## WEST SUSSEX COUNTY COUNCIL CONSULTATION

| <b>LOCATION:</b>                | Land at Stanhorn Grove                                                                                                                                                                                                                                |
| <b>SUBJECT:</b>                 | <b><u>FP-171-18</u></b><br>Development of 18 residential dwellings and new access onto Stanhorn Grove                                                                                                                                                 |

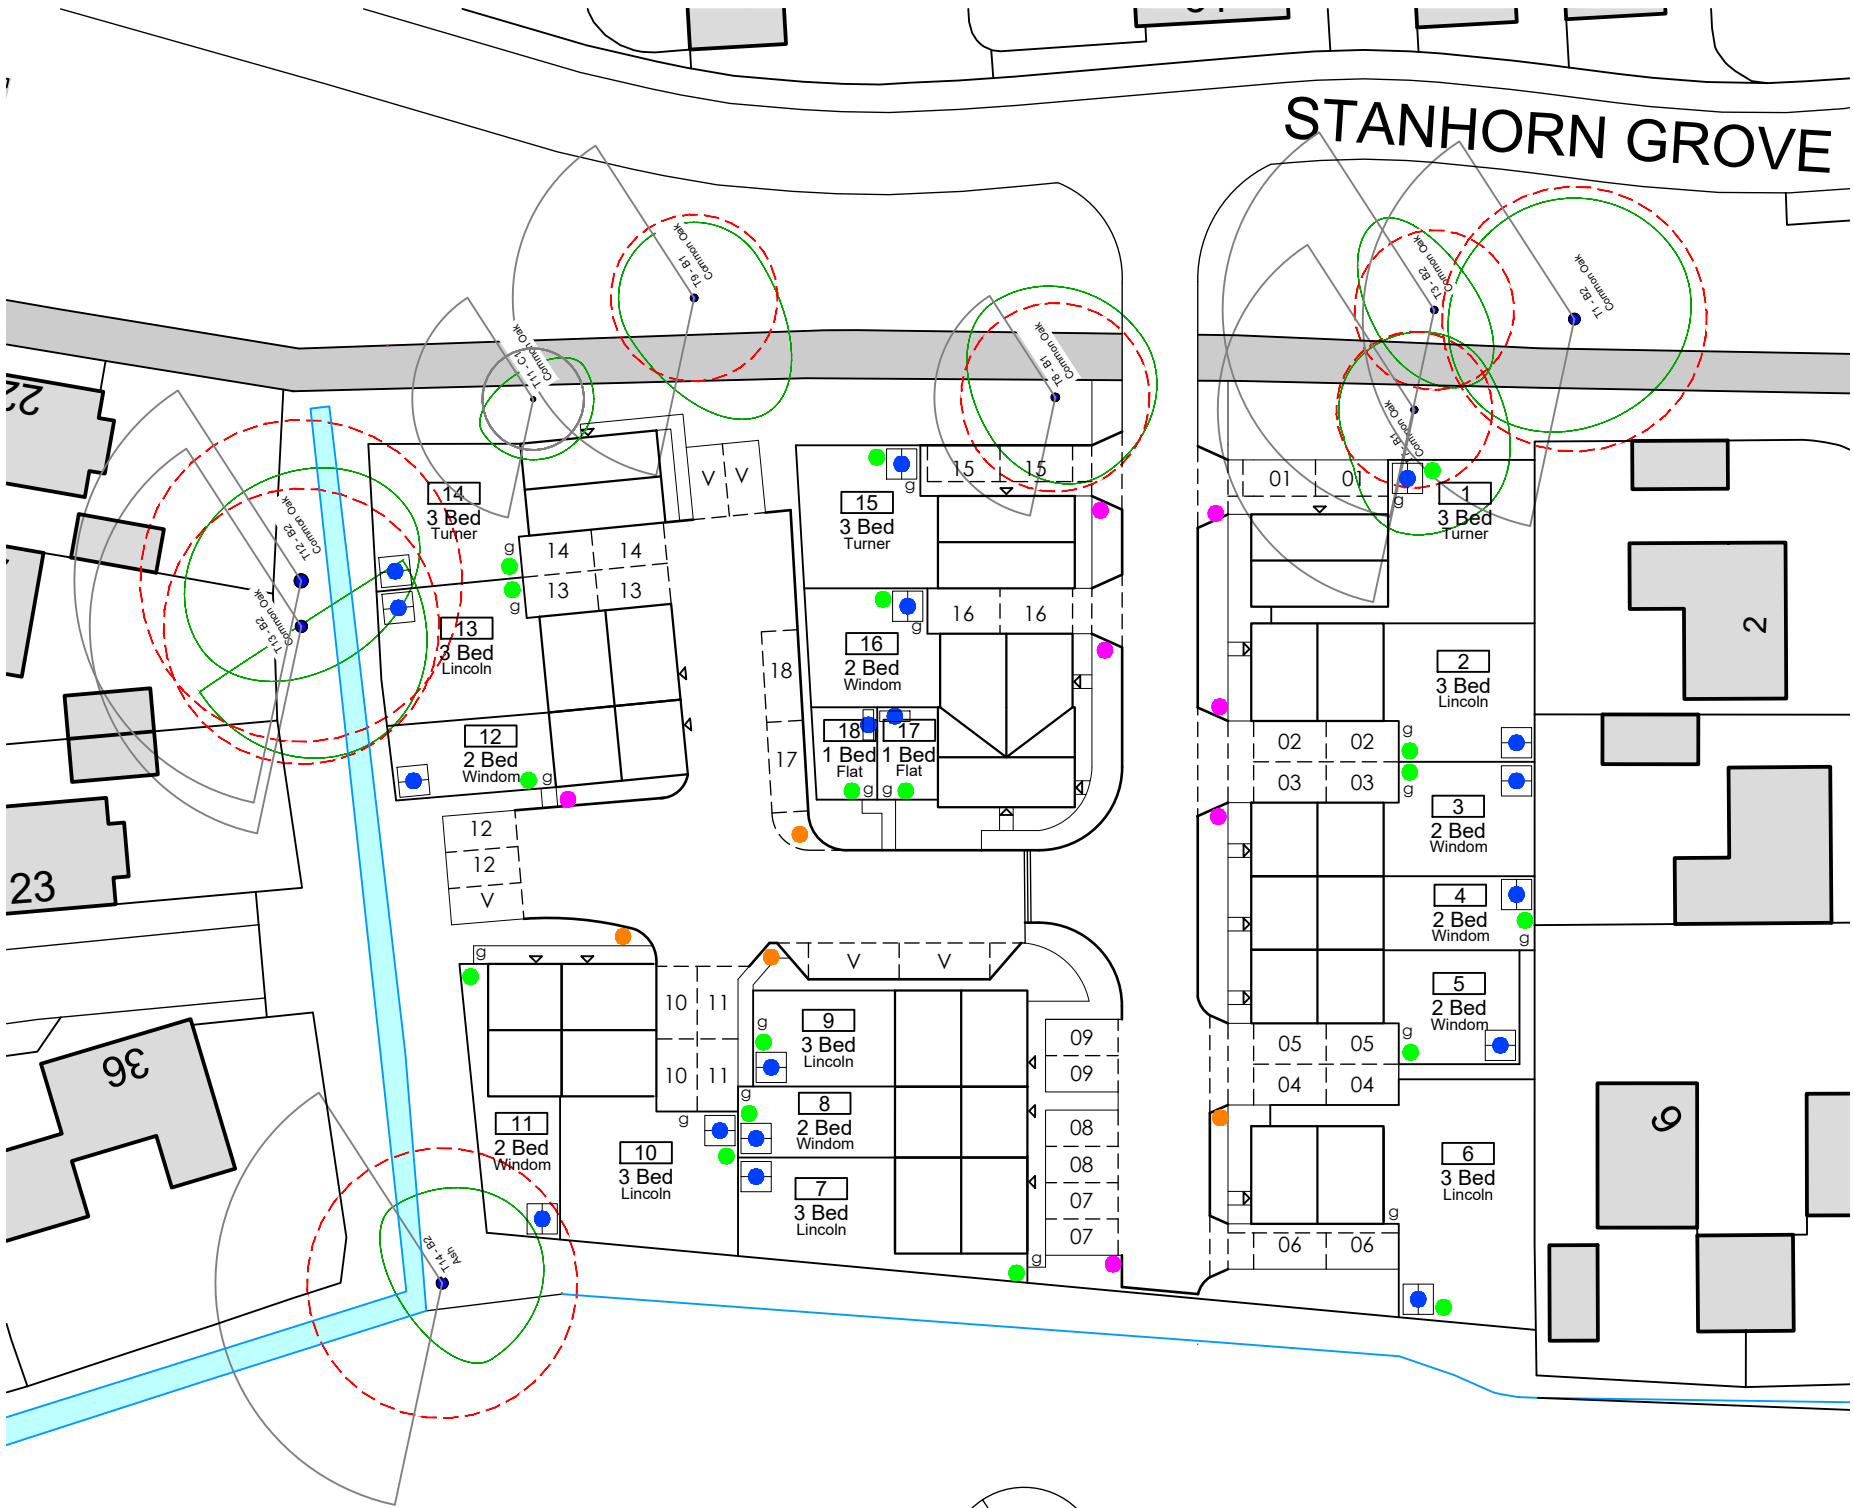
The car parking strategy is 1 space per 1 bed and 2 spaces for each 2/3 bed property. The WSCC car parking calculator has been considered and attached to this correspondence which is in line with the car parking proposals. Each car parking space must be 2.4m x 4.8m minimum to enable a standard car to use the space. From reviewing the plans these are within these dimensions, as is the proposed visitor parking provided.

No part of the development shall be first occupied until the car parking has been constructed in accordance with the approved site layout parking/cycle parking plan (17094-PL-2-08). These spaces shall thereafter be retained at all times for their designated purpose.

No part of the development shall be first occupied until covered and secure cycle parking spaces have been provided in accordance with plan (17094-PL-2-08)
